Your Ref: OWPC7198
Our Ref: EP/120/15/HH 11-09-2015
Please ask for:
Mrs A Gardner

Remodelling & extensions
Hascombe 33 Tamarisk Way East Preston

Thank you for your internet representation made on 18th October 2015 which has been recorded as '**an objection**' with the comments as follows:

client	Jason Richardson
job	Hascombe Tamarisk Way East Preston West Sussex
dwg no.	1043.06e
title	Proposed Ground & First Floor Plans
drawn by	SM
checked by	KT
scale	1:100 @ A1
date	05.08.15

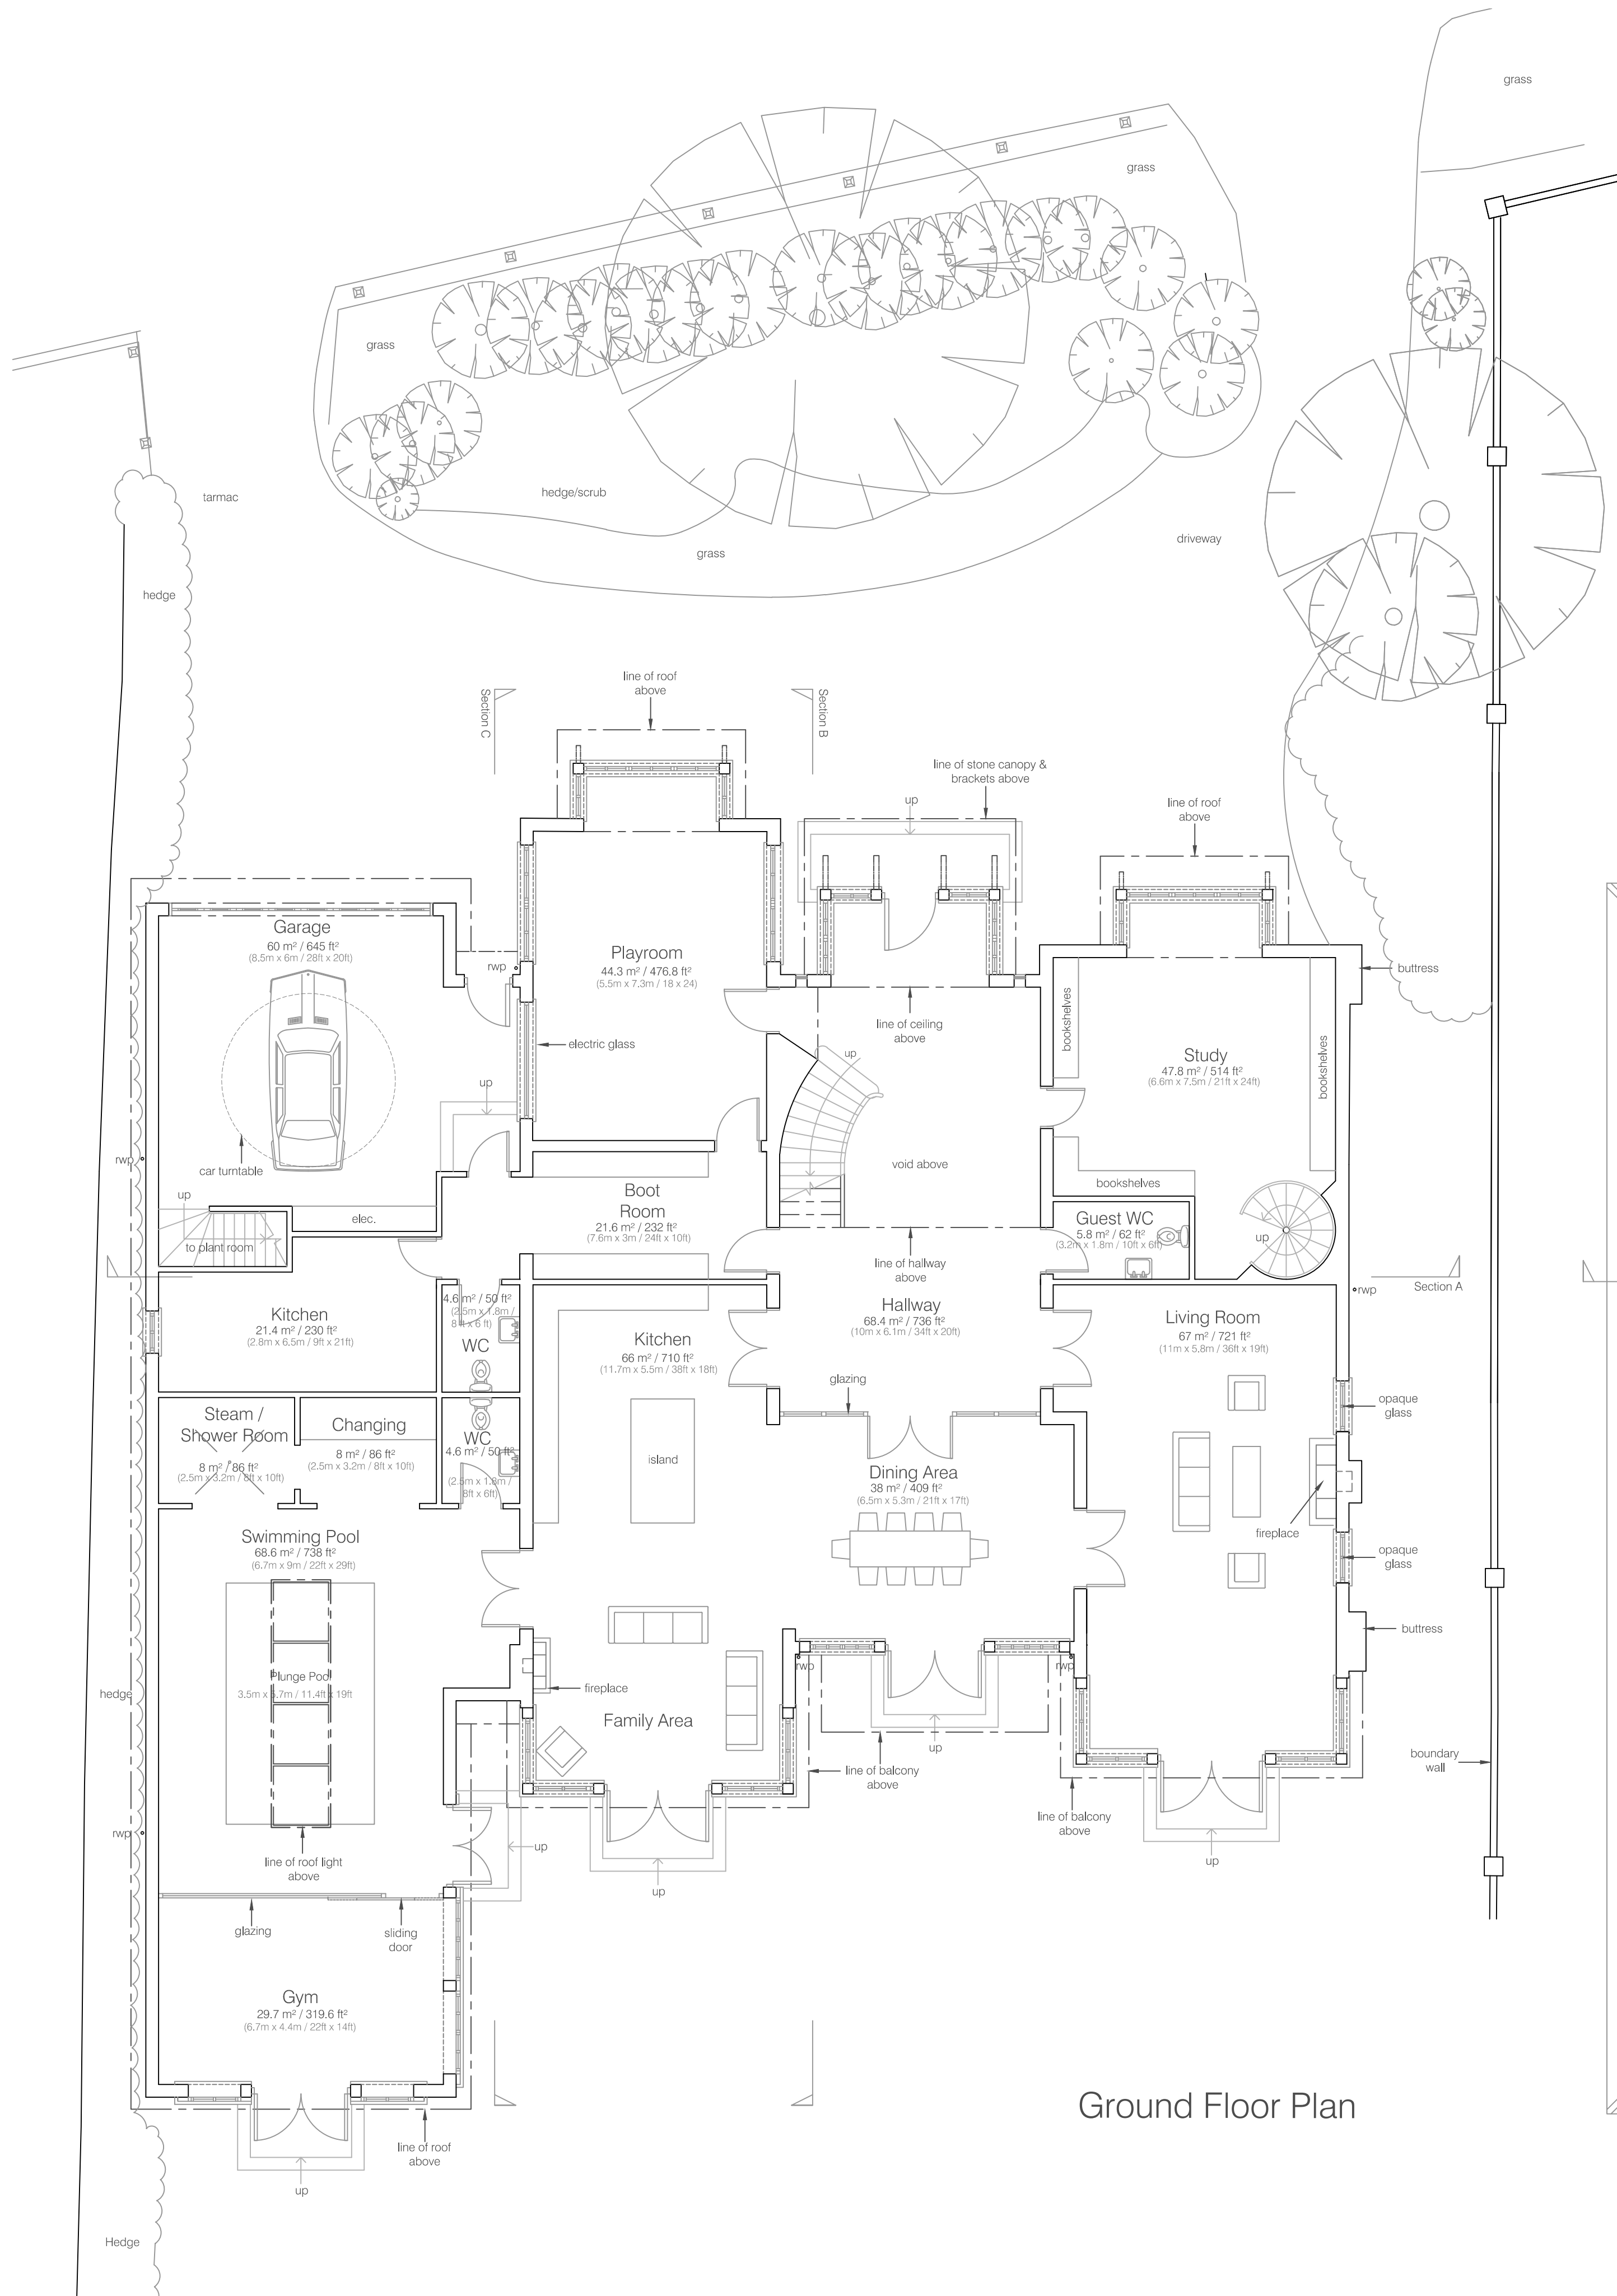
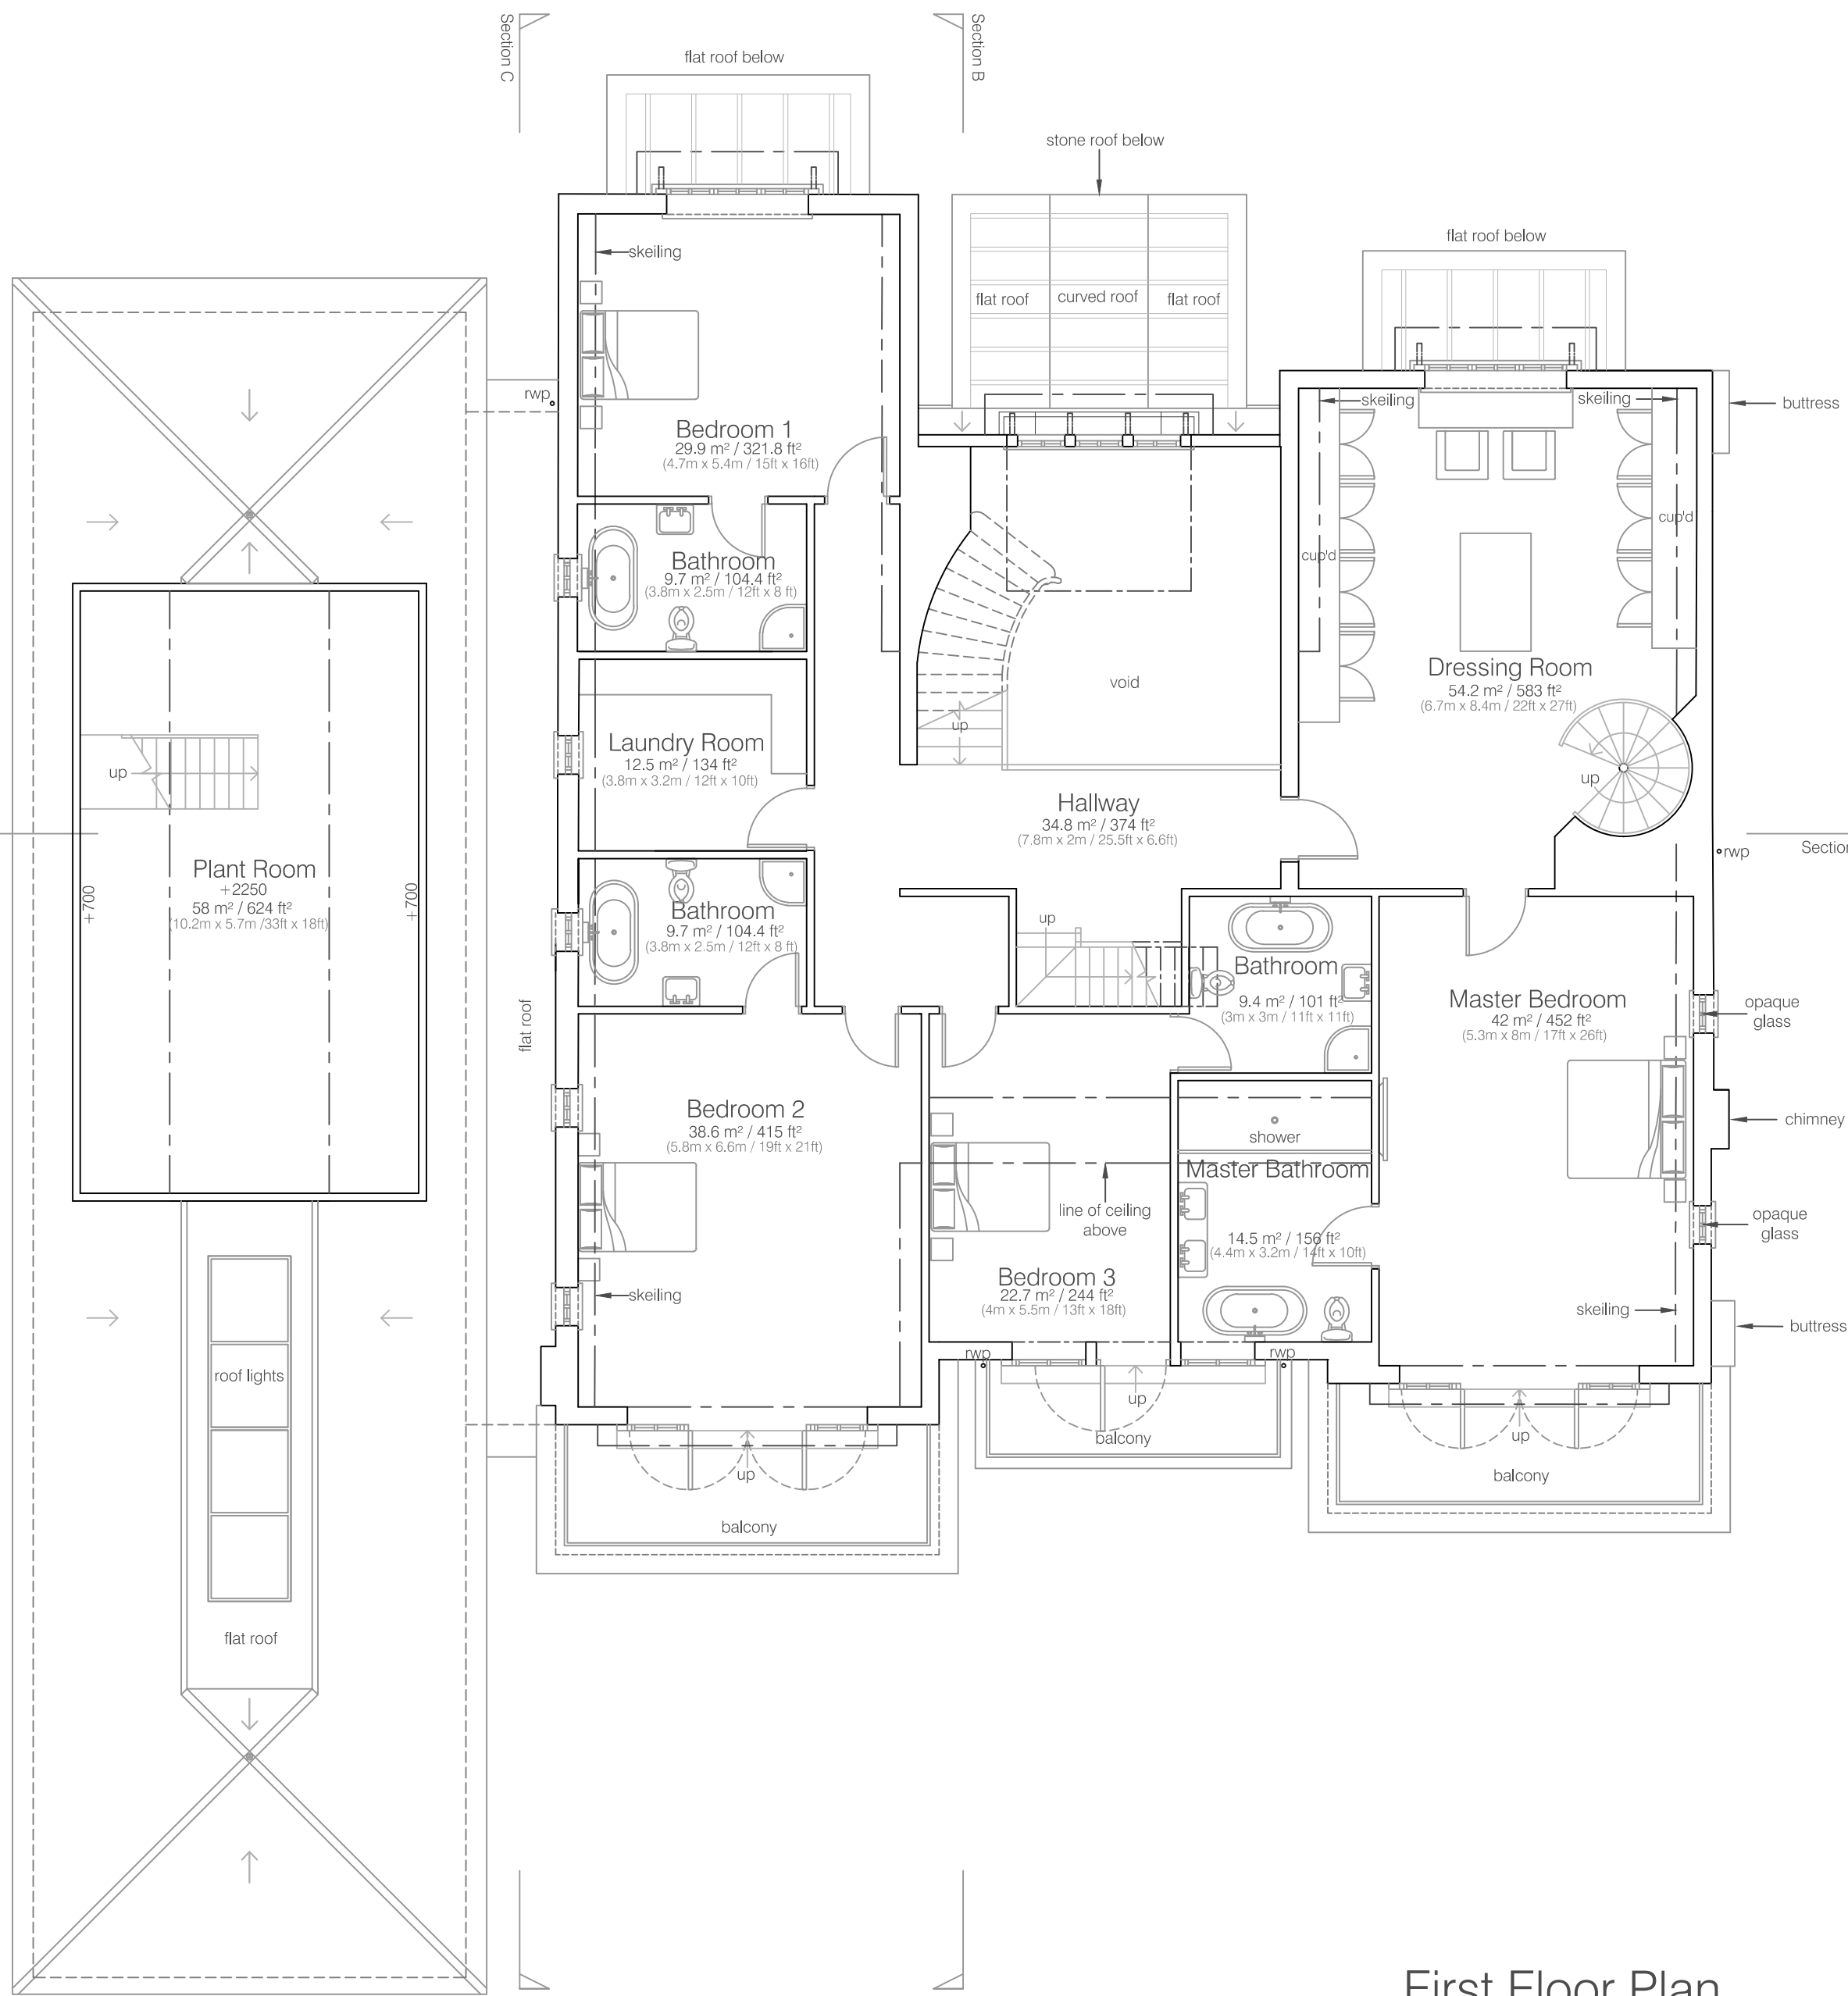
Although I was pleased to see plans for the improvements to the front of Hascombe, I was more than taken aback to see plans for the proposed rear and side extensions, which far exceed the lines of the current footprint and, more importantly, the lines on which other houses in the front row of Tamarisk Way houses sit. I feel that this will not only have an impact on the privacy and light of Flagstones, but also will have an impact on the overall feeling of space intended by the original developers in the 1930s to create substantial houses with spacious gardens. As a dog walker, the proposed West elevation will overwhelm the grass walkway down the side of Hascombe both in extent and proximity to the boundary, which is visible from my flat at Fosters. It would seem to me that the compromise would be to remove the first floor elevation from the rear (which includes part of the Master bedroom, bedrooms 2 and 3 and dressing room), and to keep the ground floor extension below the height of the top of the current balcony. The proposed house is too big for the plot, and is inconsiderate to both existing neighbours and residents of the estate. I would urge all residents to look closely at the plans online.
